PRELIMINARY SITE GRADING CONSTRUCTION PLANS
FOR
LORSON RANCH EAST
EARLY GRADING / EROSION CONTROL PLANS

PUDSP-16-003

PCP Redlines #2
8/14/17 RLS

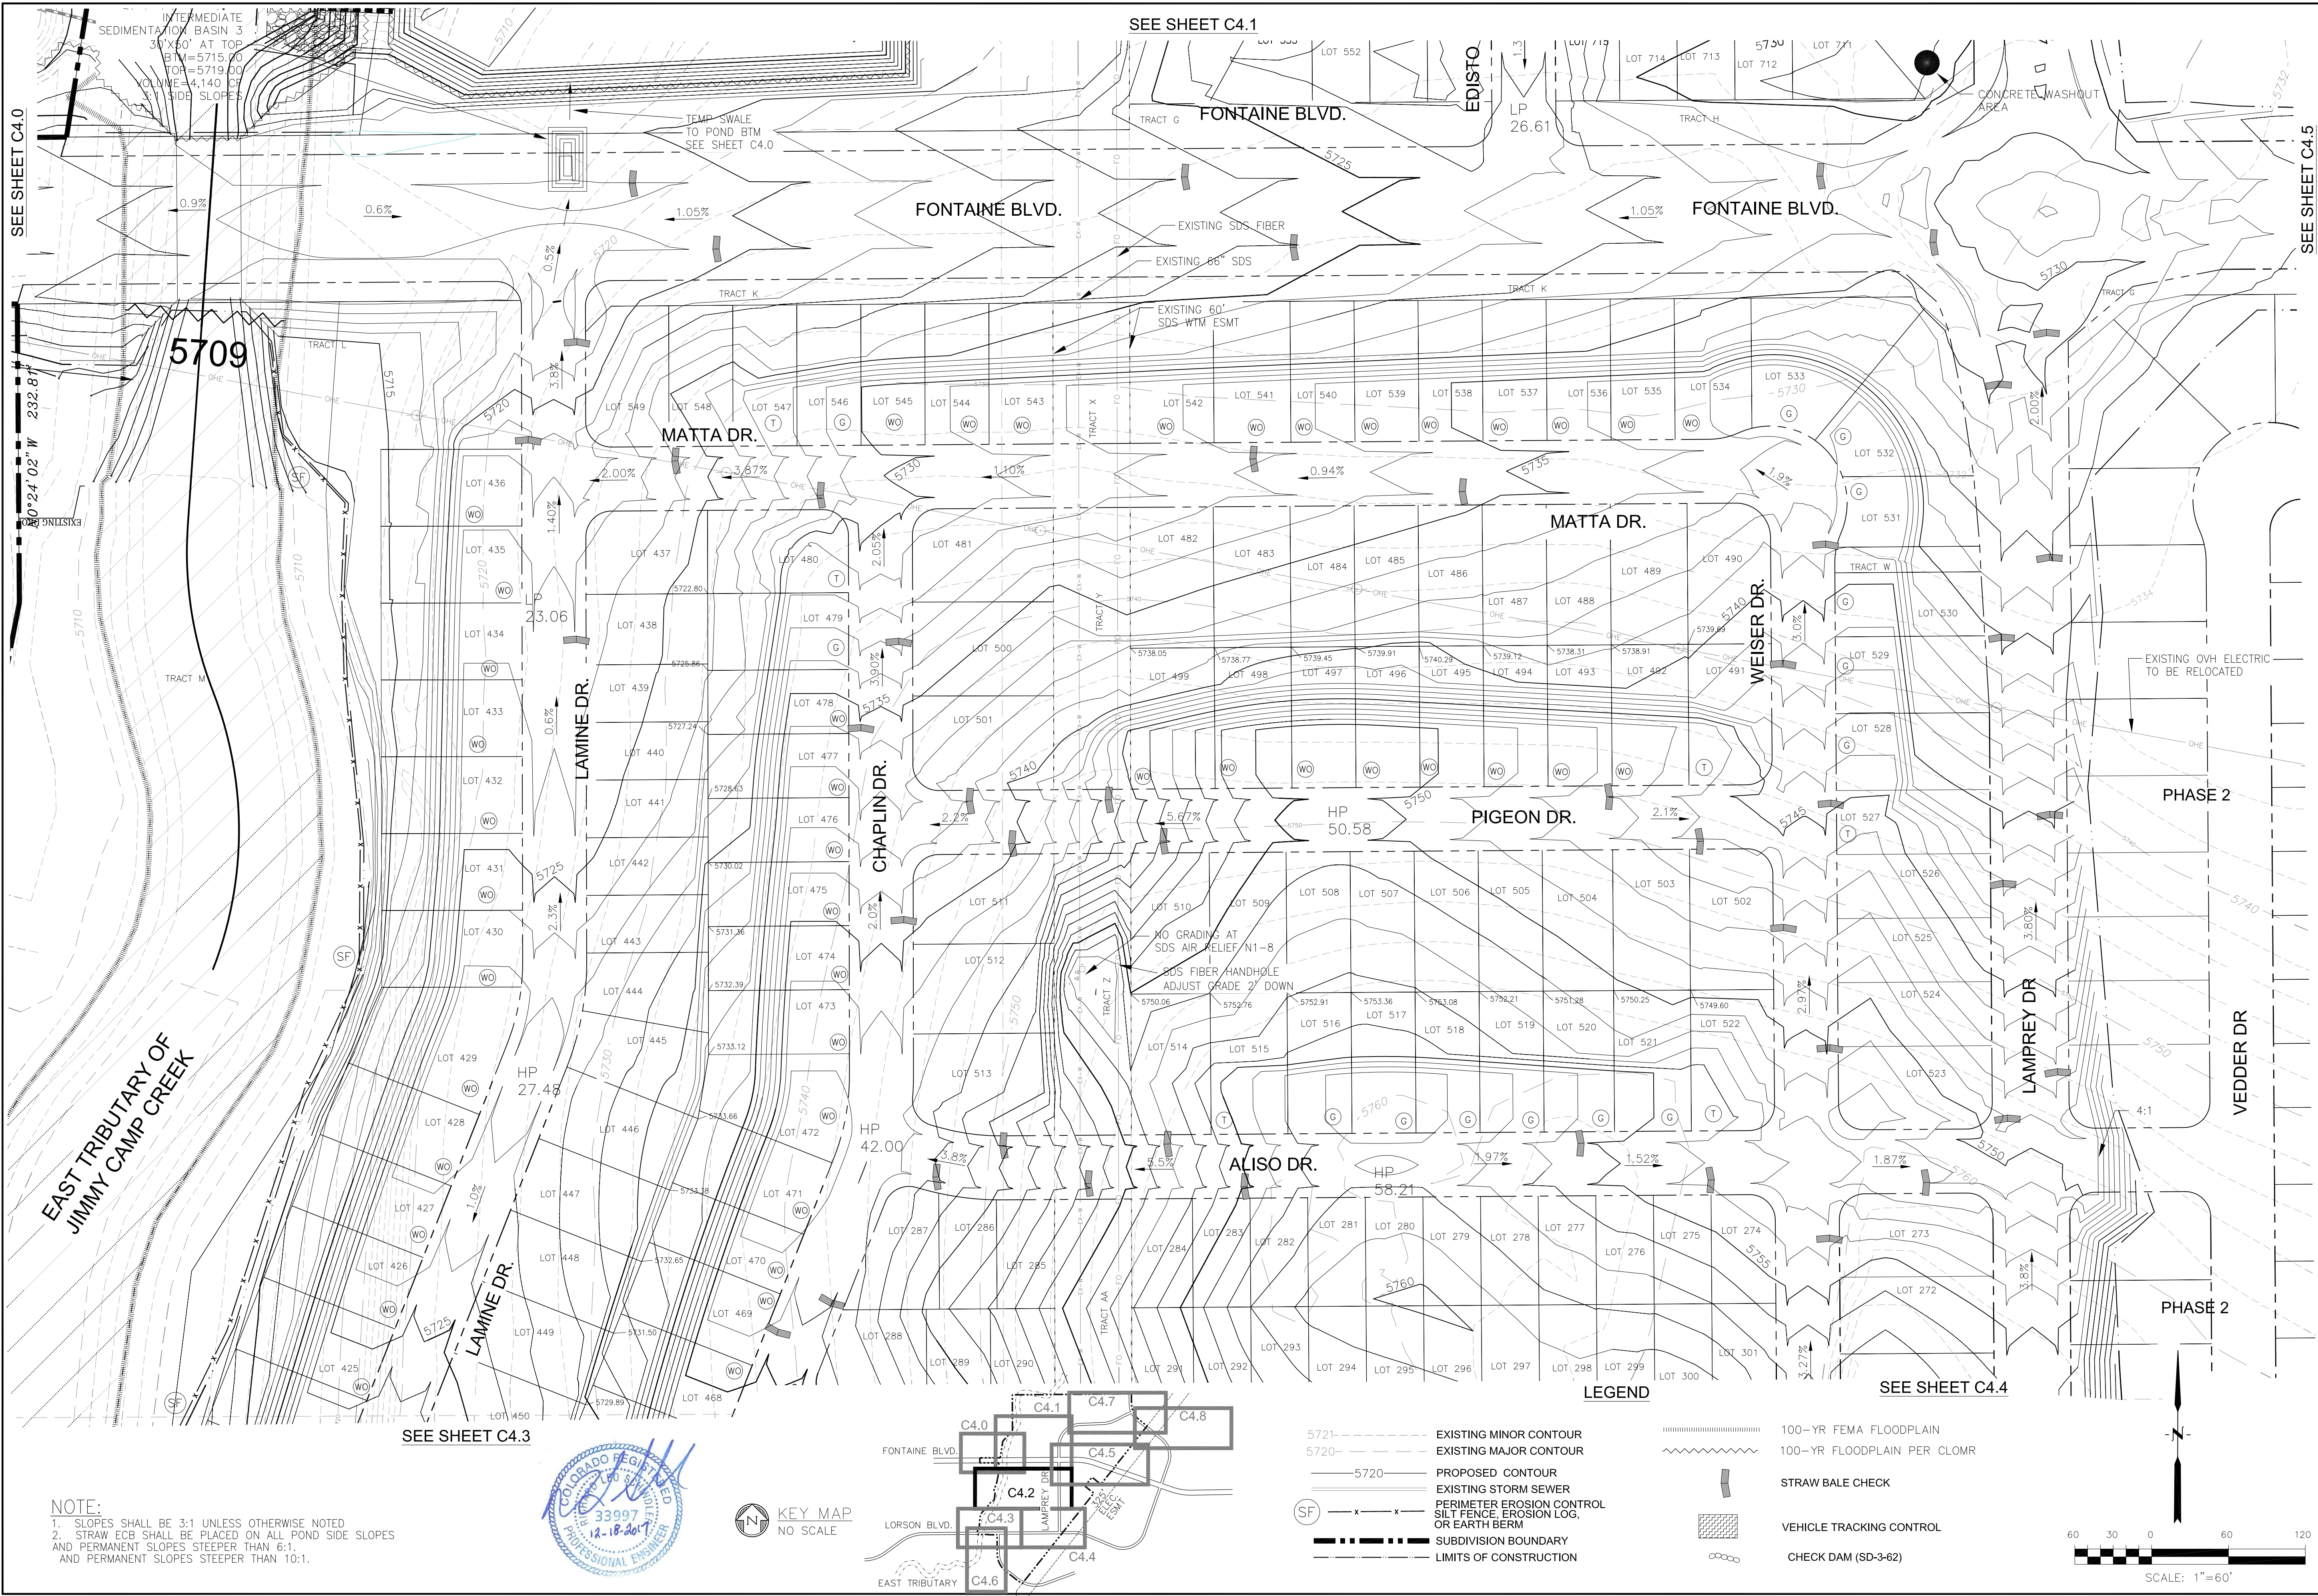
When are channel improvements being considered?

Outfall protection?

FULL SPECTRUM DETENTION POND D2
LORSON RANCH EAST

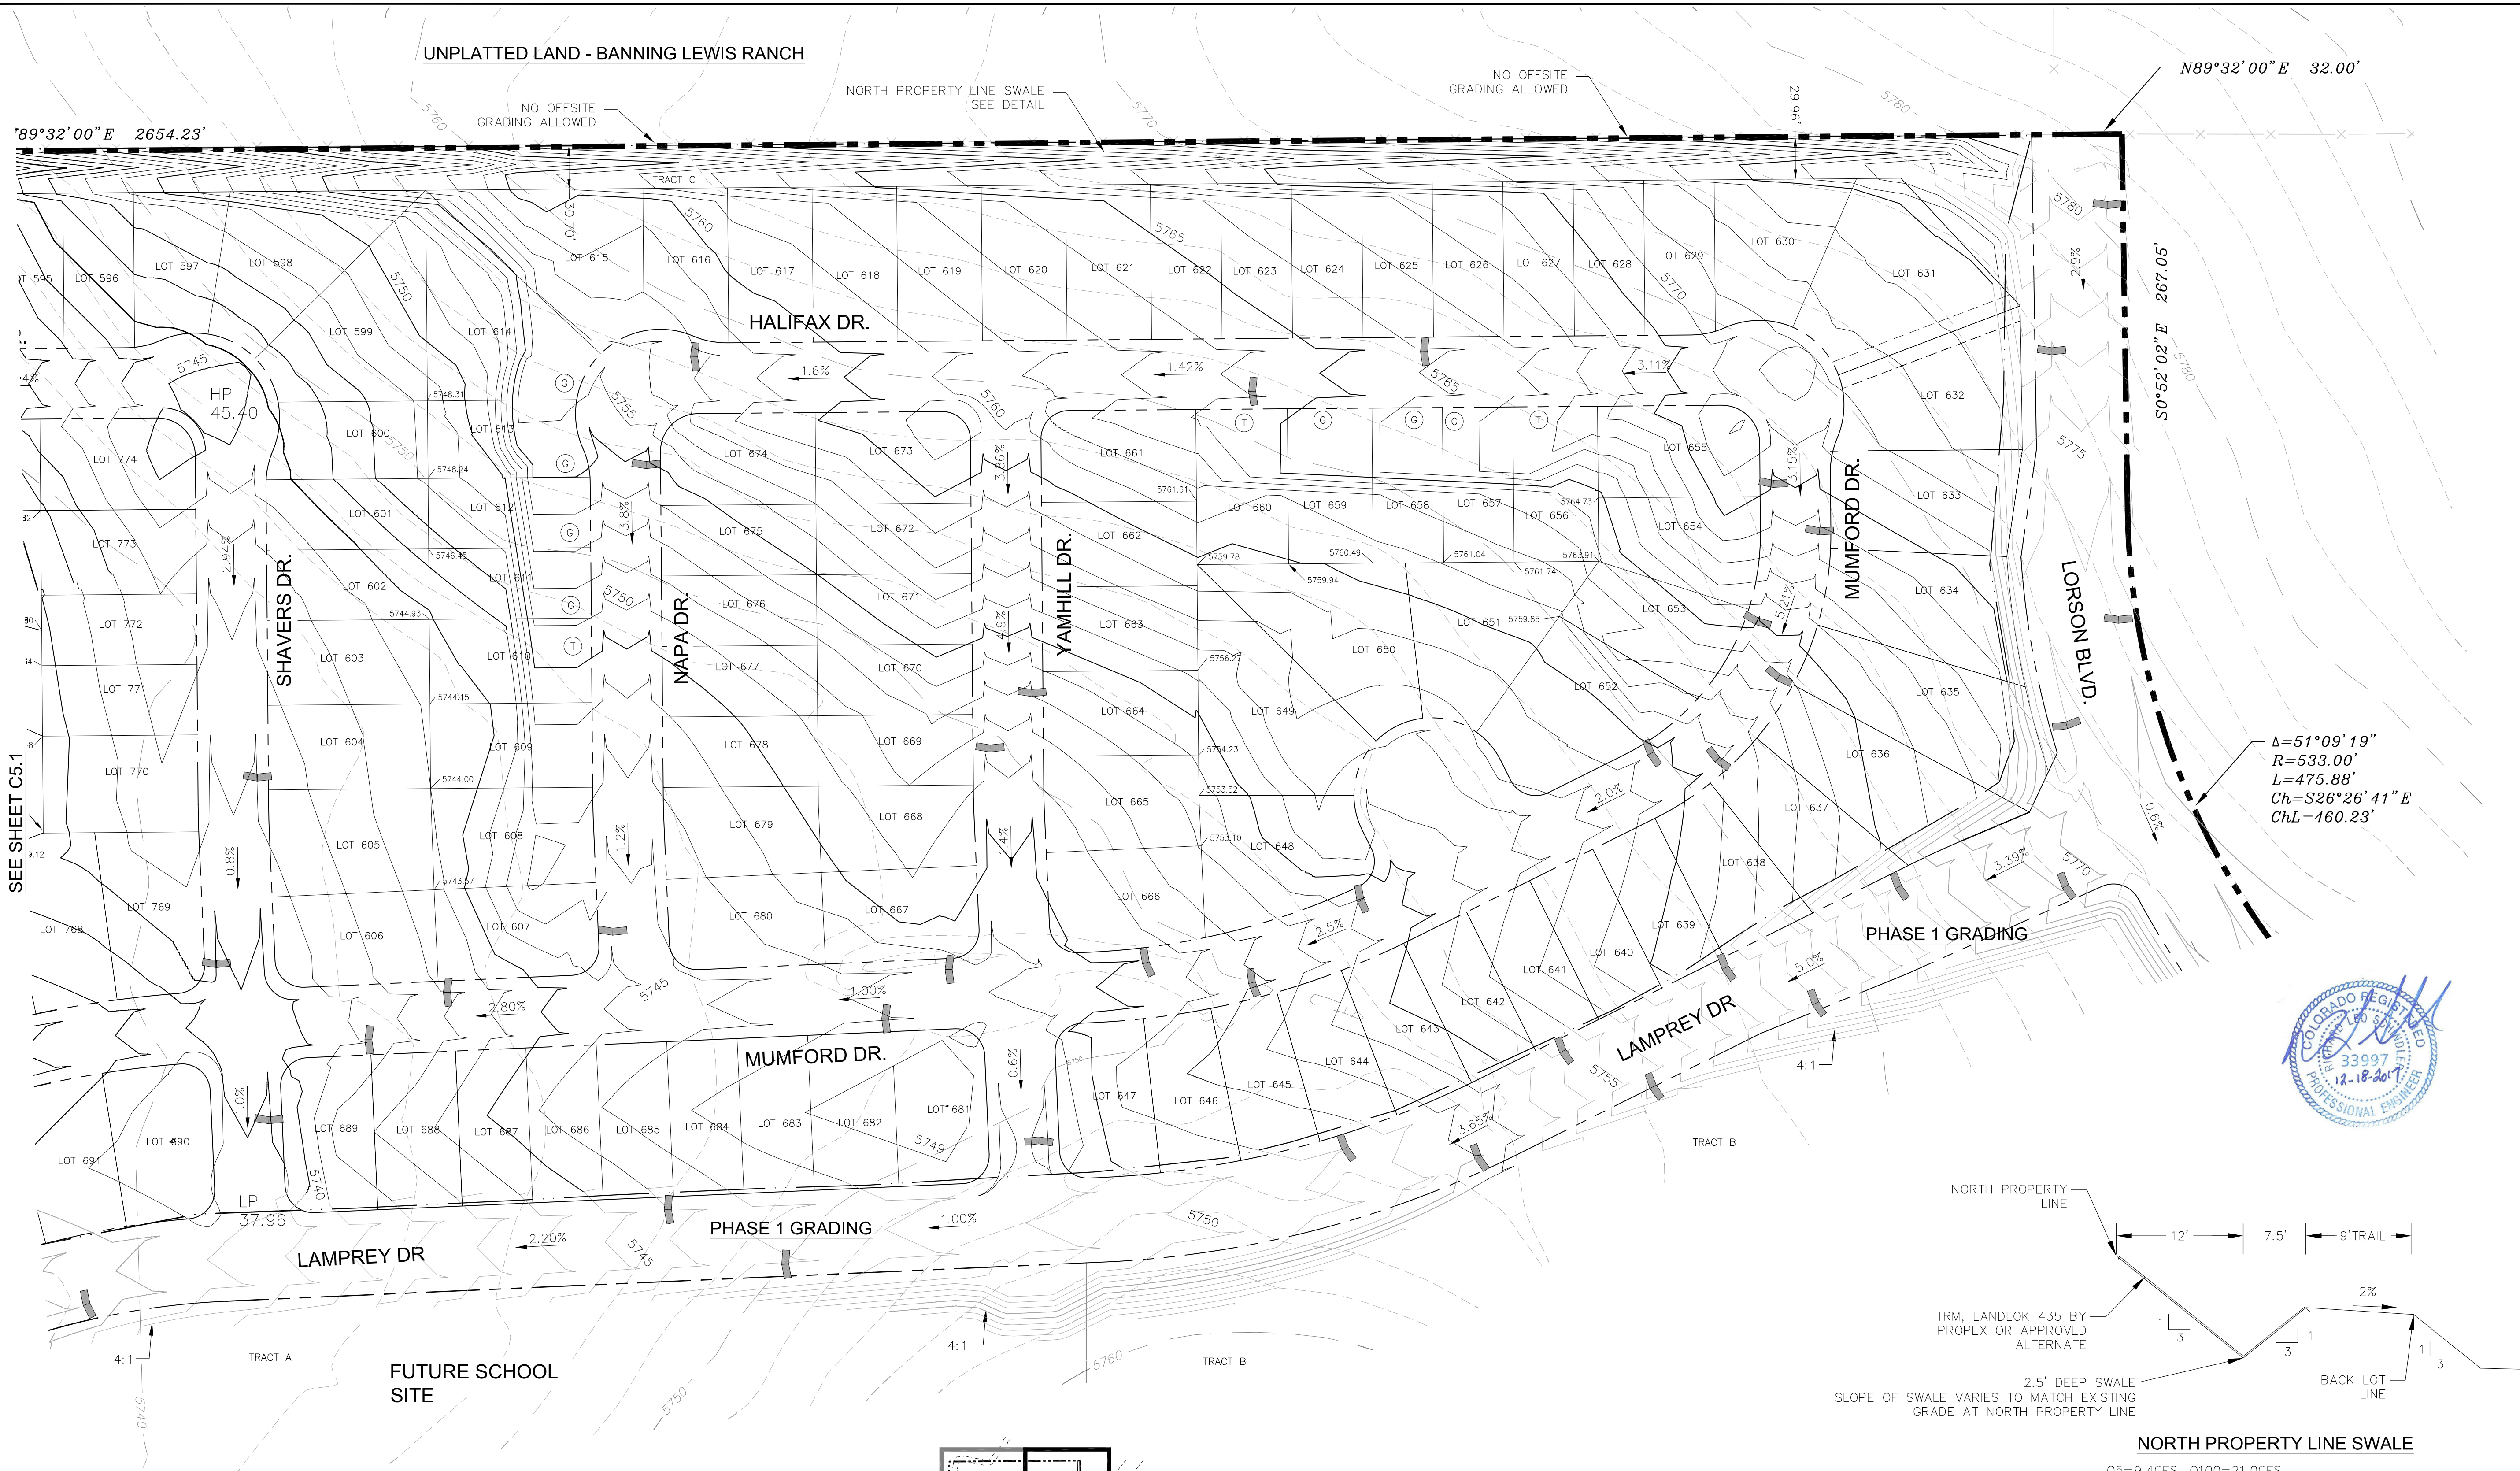
EAST TRIBUTARY
 Provide access to bridge

provide profile/section
 ?

Show access

OK for trail?
 trail?
 Show

provide access to bridge

*provide profile section
 Show manit access/trail*

SHEET NUMBER
C5.5

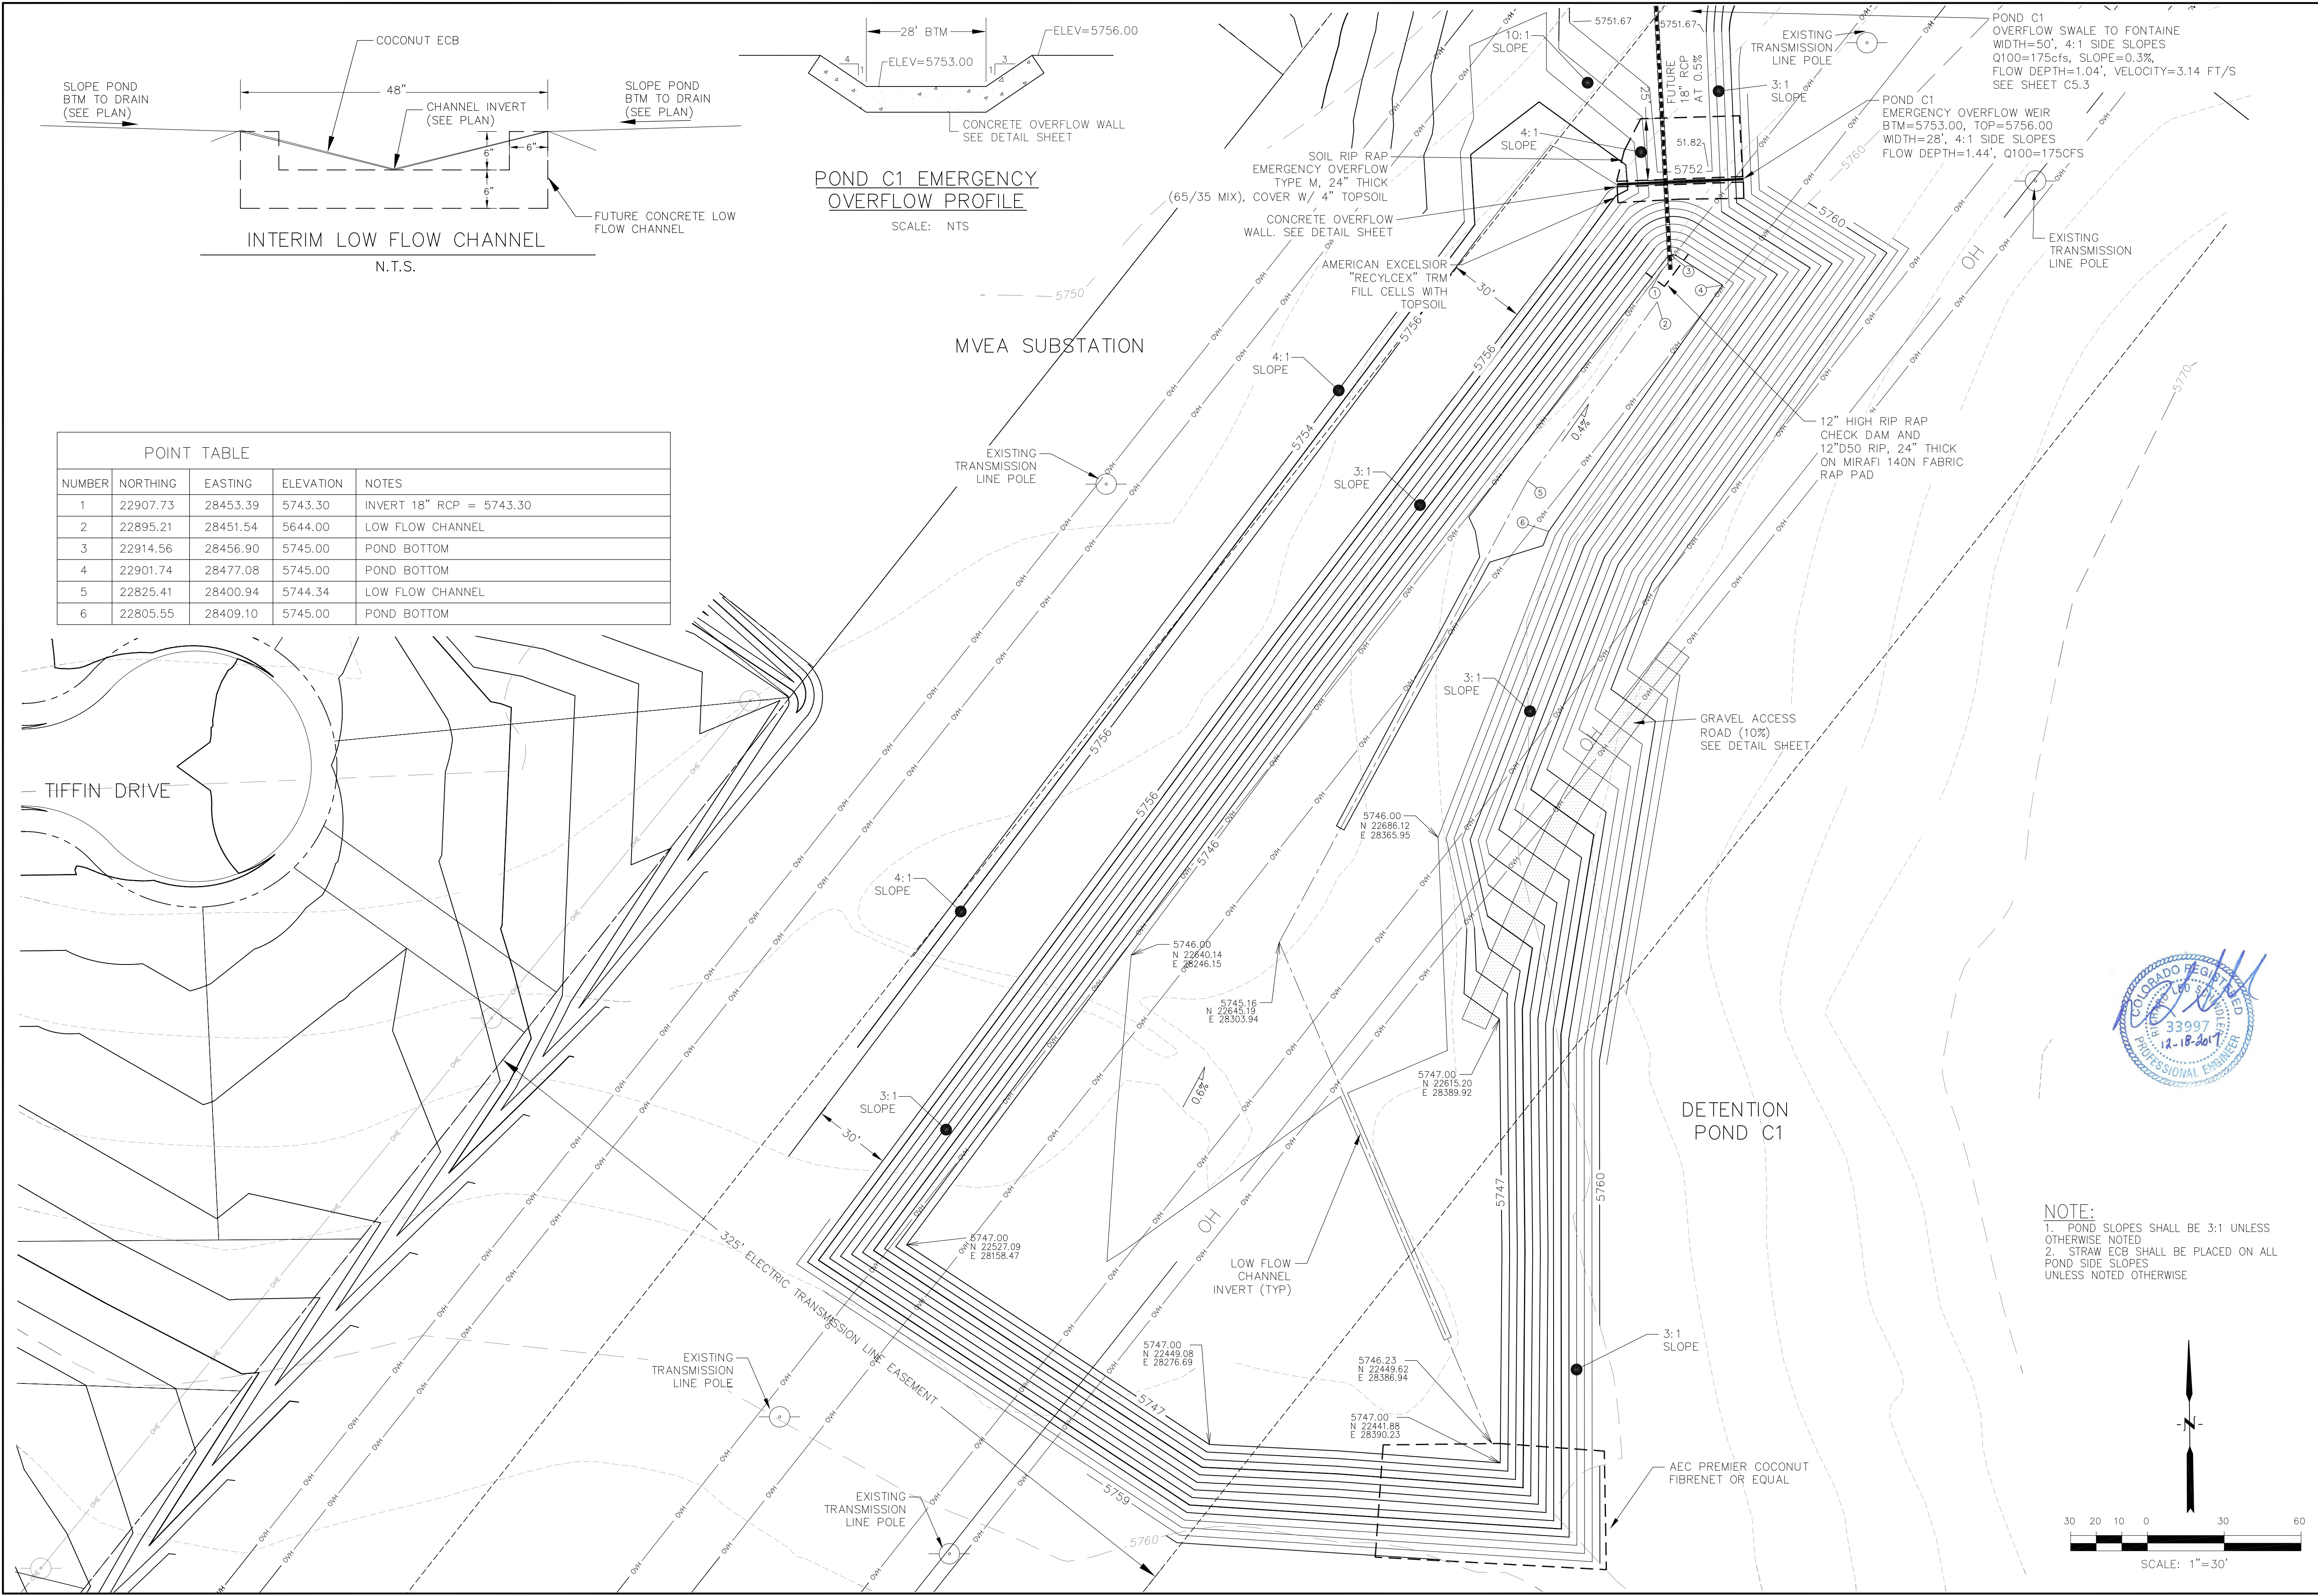
Where is boundary?

*not to County Row
offsite grading (label all)*
